RE: 661 Allen Ave., Permit # 071319
CBL: 398-B-016001

This letter is a follow up to the meeting on January 27, 2009 in the Inspections Office at City Hall with you and Bob Greenlaw. Thank you for the timely response to my phone call that day to Bob regarding the installation of the Big John outdoor wood boiler. You confirmed yesterday that this appliance was installed sometime in November of 2007 without benefit of approvals. During my review process, Bob Greenlaw was the primary contact; he did supply additional information per my request. After his last submittal on December 5, 2007 and a subsequent conversation on December 11, I requested further information, which has not been submitted to date:

PROPOSED STOVE PIPE INSTALLATION

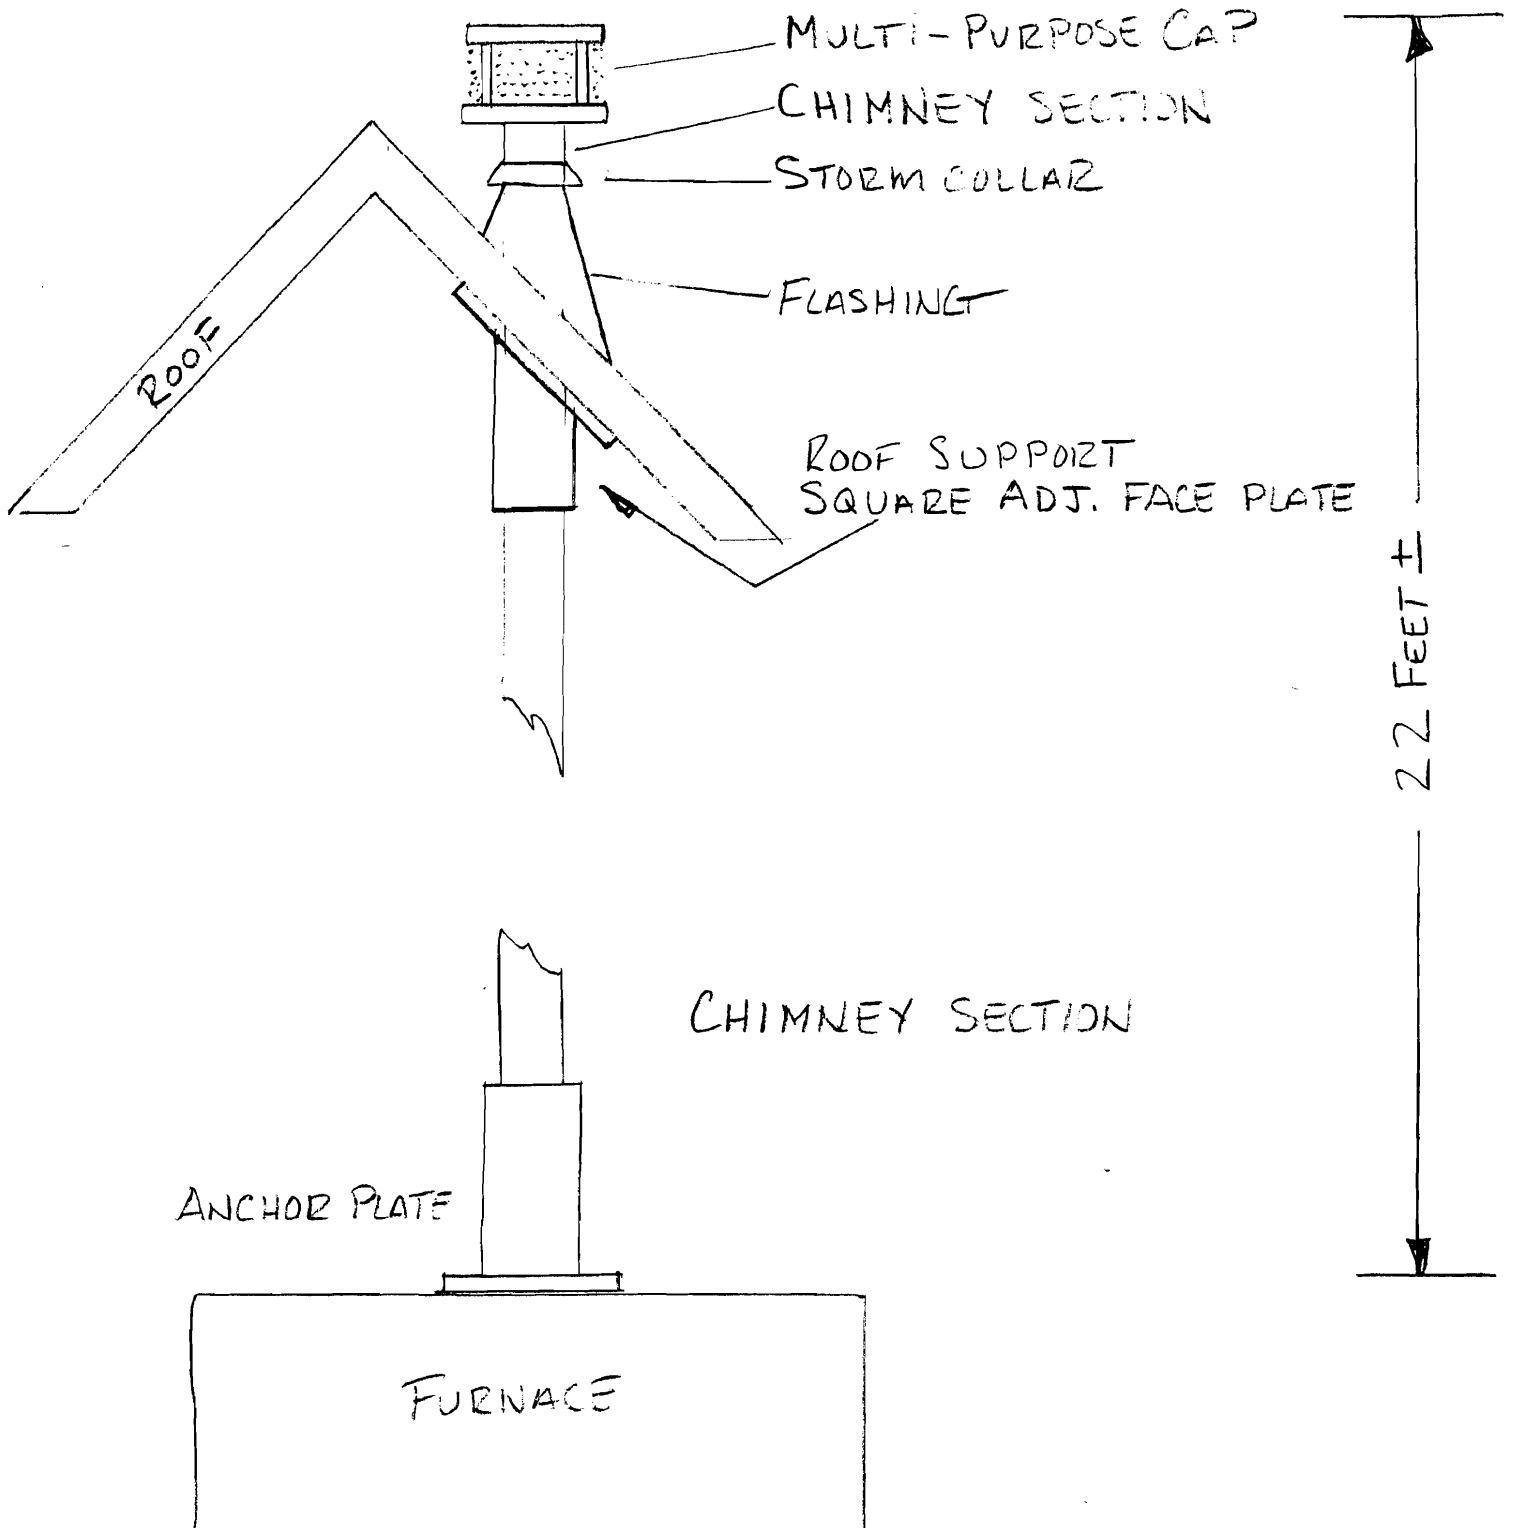
1. Accurate verification of required clearance to combustibles or compliant reduction method
2. Certification that the appliance meets DEP emissions control standards, setbacks to property lines and stack heights.
3. The extension pipe/stack specifications
